PLANNING AMENDMENT

Application No. H13/0962/95
Date Registered 01 NOV 1995
Case Officer *DX*

ERECT GARAGE AND STORE BUILDINGS WITH
FUNCTIONAL ROOM ABOVE (DEADEN EXISTING GARAGE
AND CASE STORE)

AMENDMENT OF DESCRIPTION TO INCLUDE
MEETING ROOM INSTEAD OF FUNCTIONAL
ROOM

FRONT (SOUTH) ELEVATION (1:100)

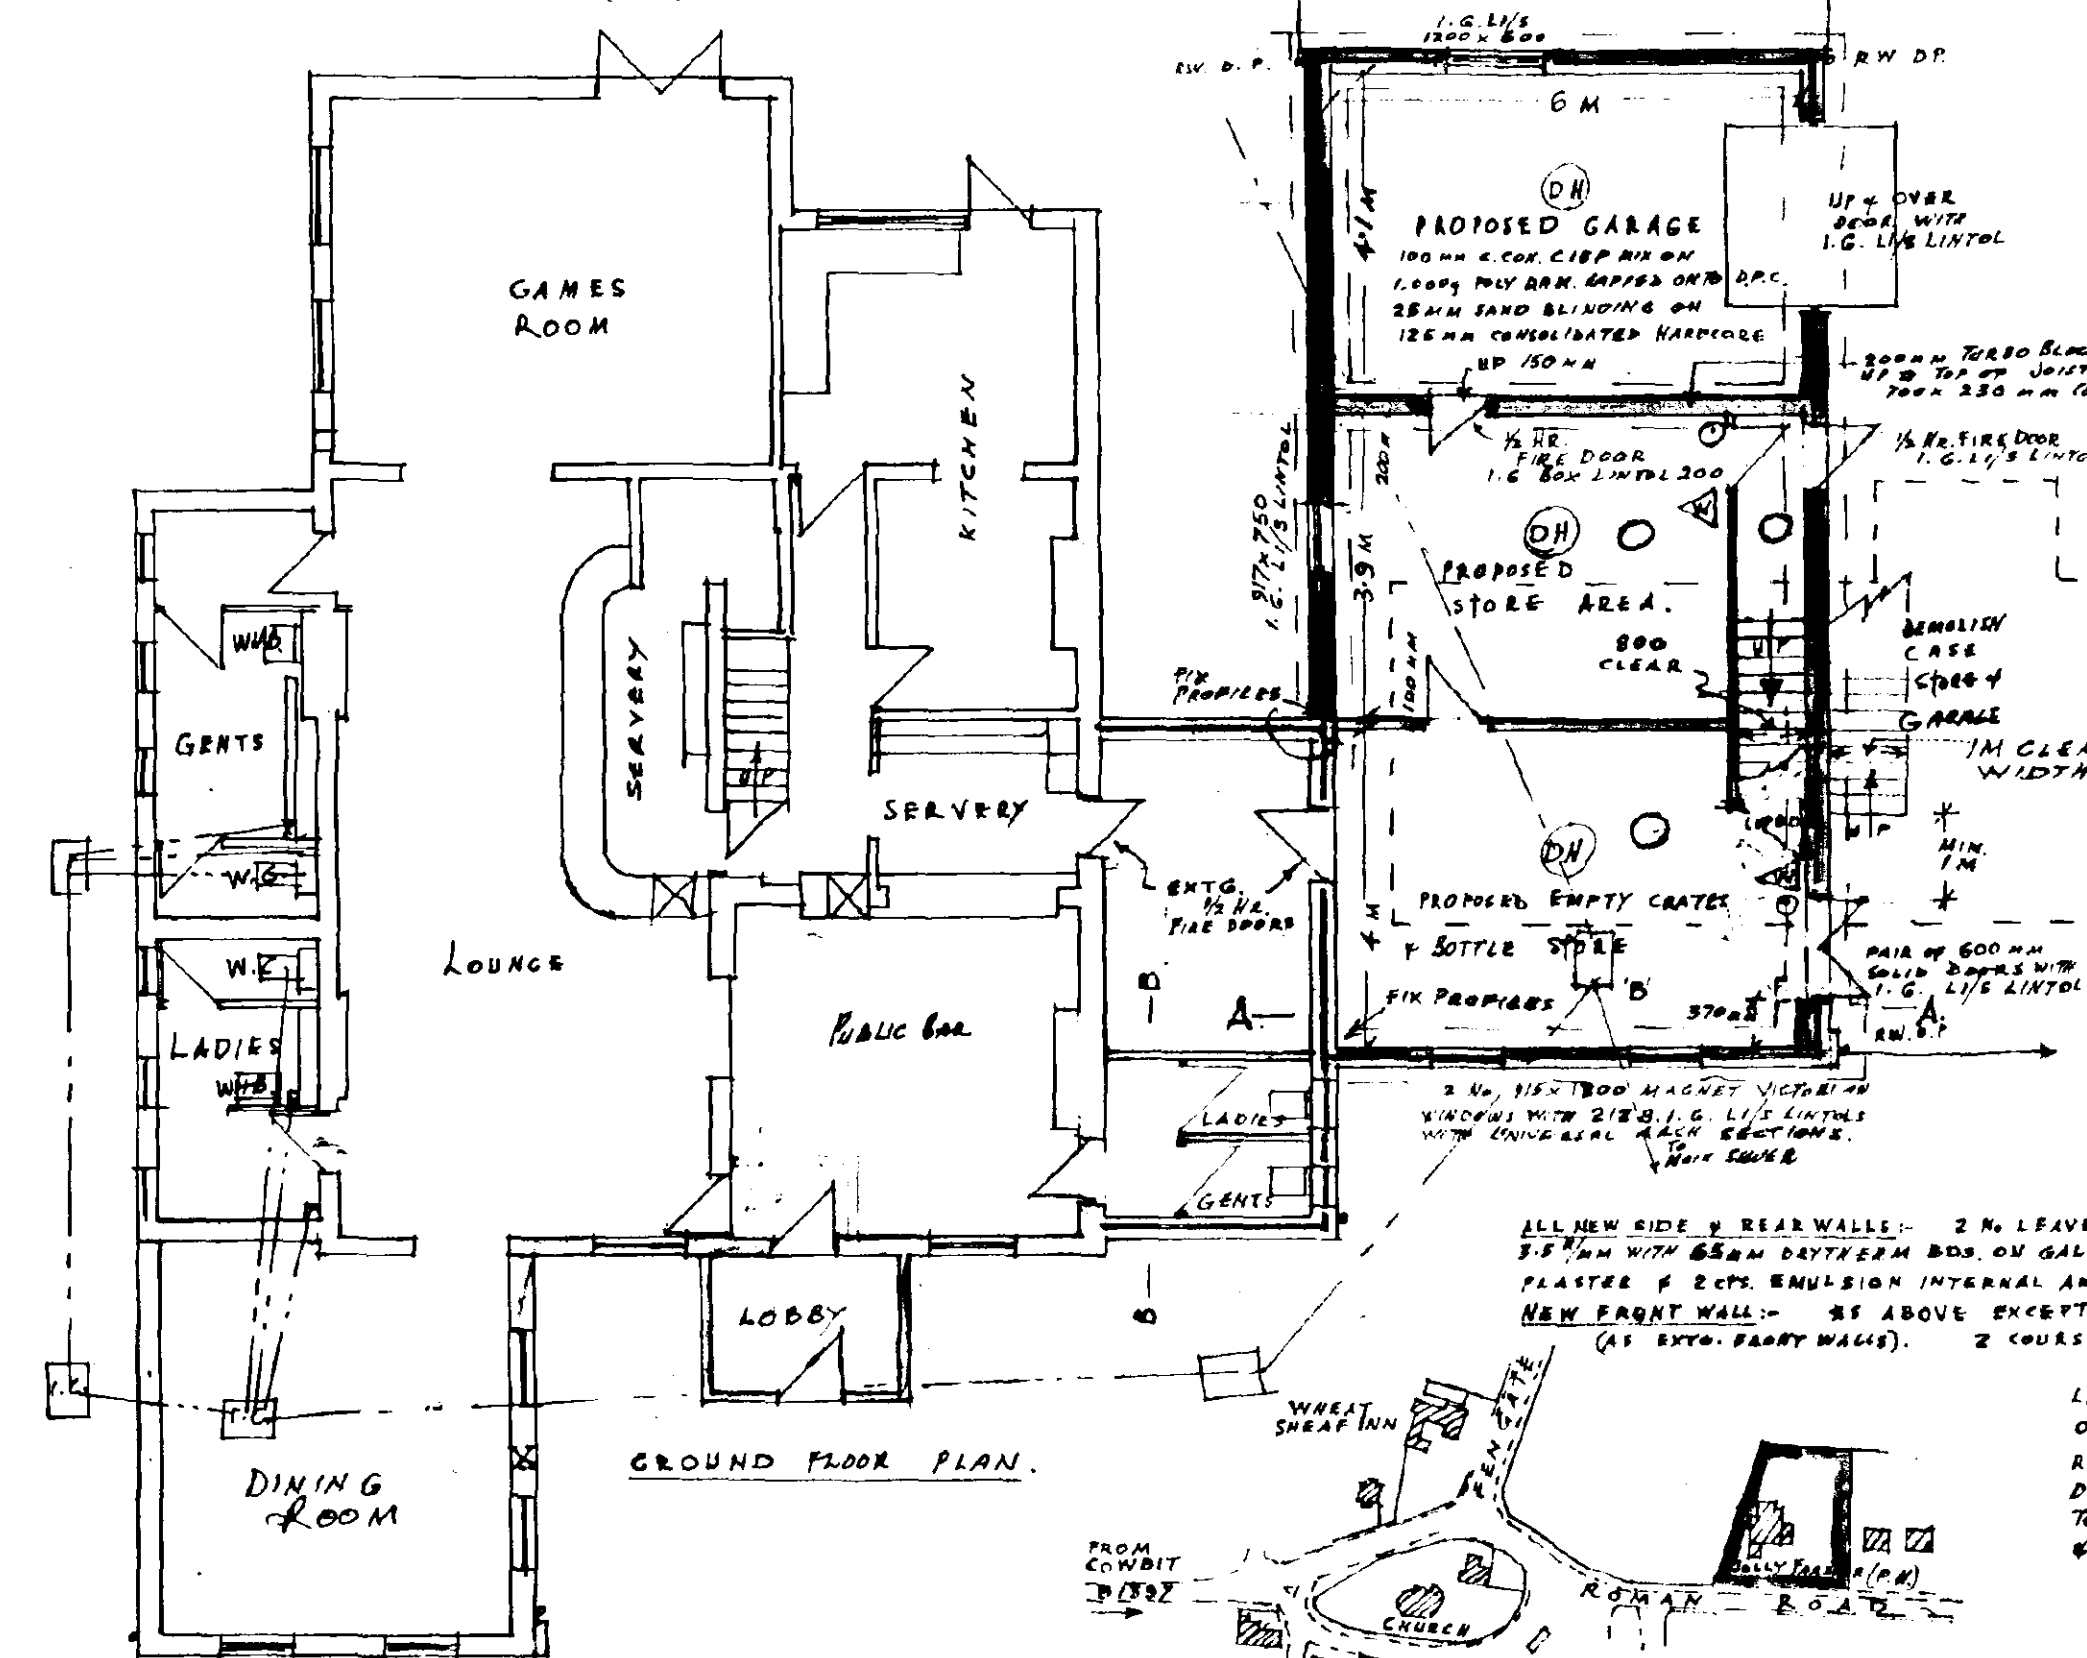
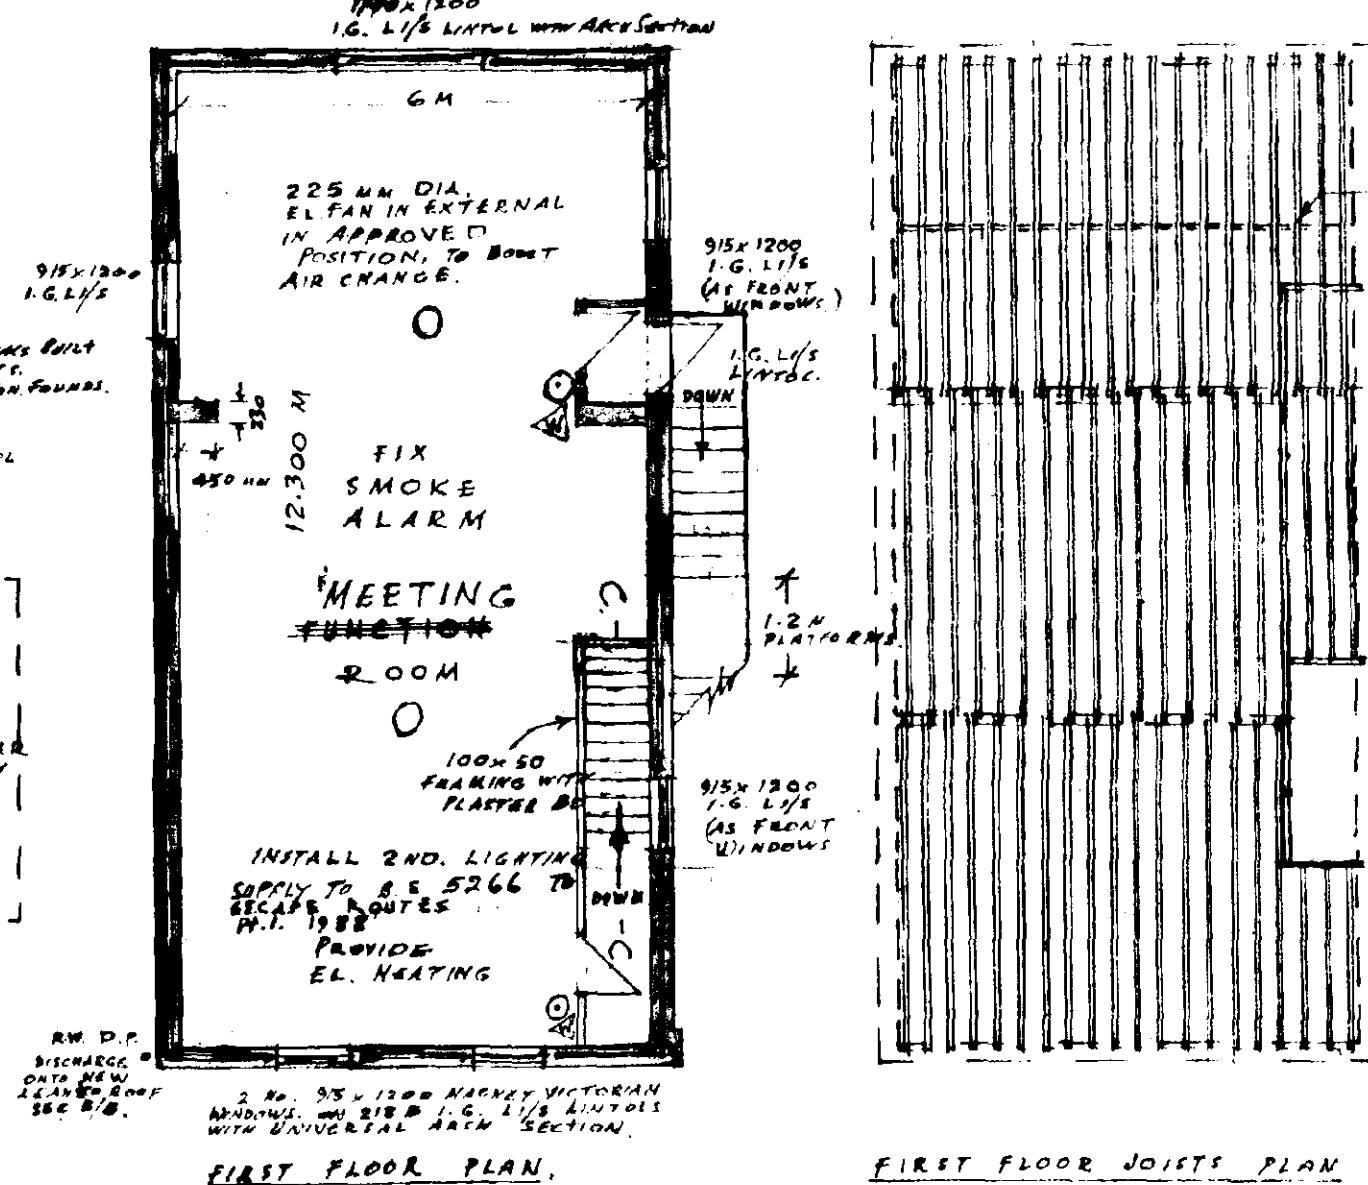
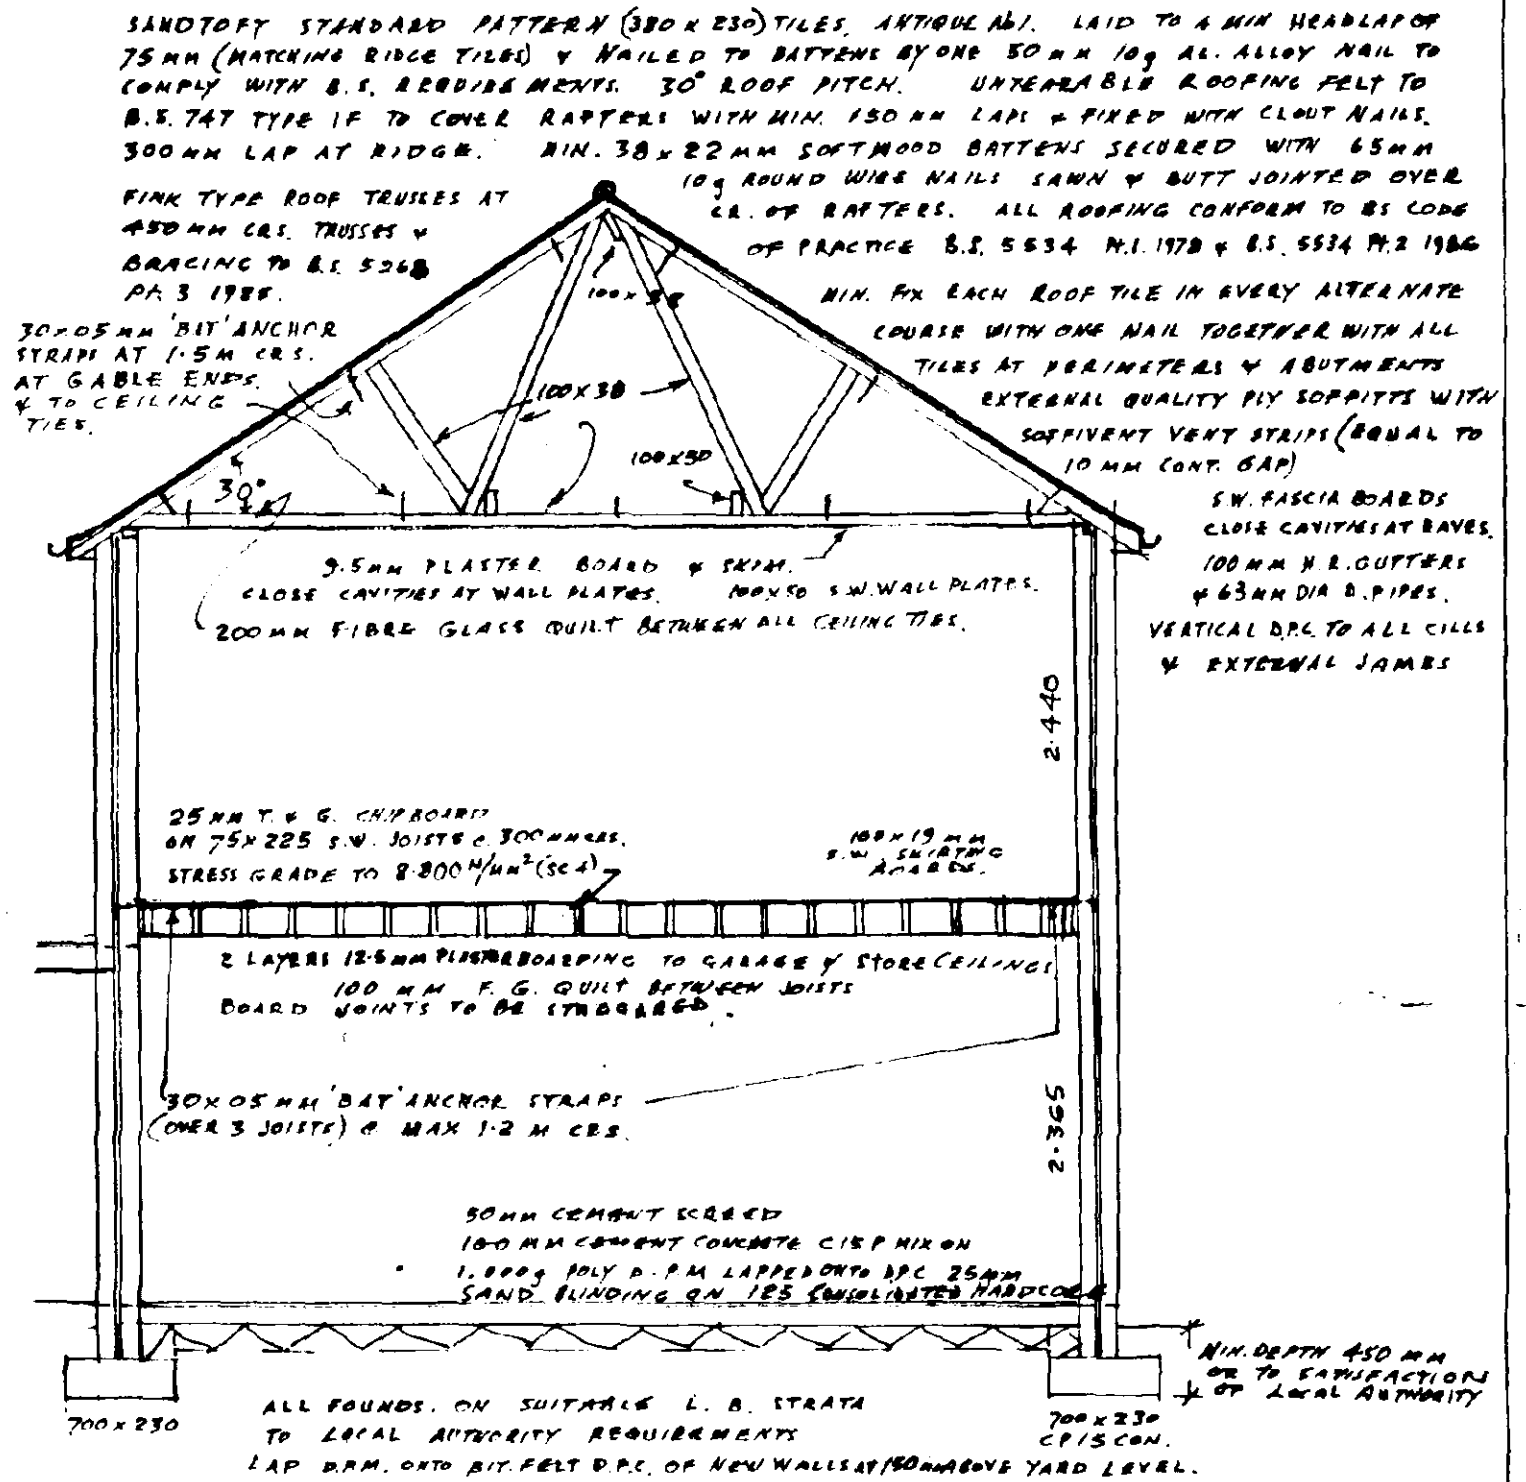
INCLUDE FOR INSULATED
PROFILE SHEETING ON SIDE
& REAR OF TOP LANDING
OF EXTERNAL STAIRS.
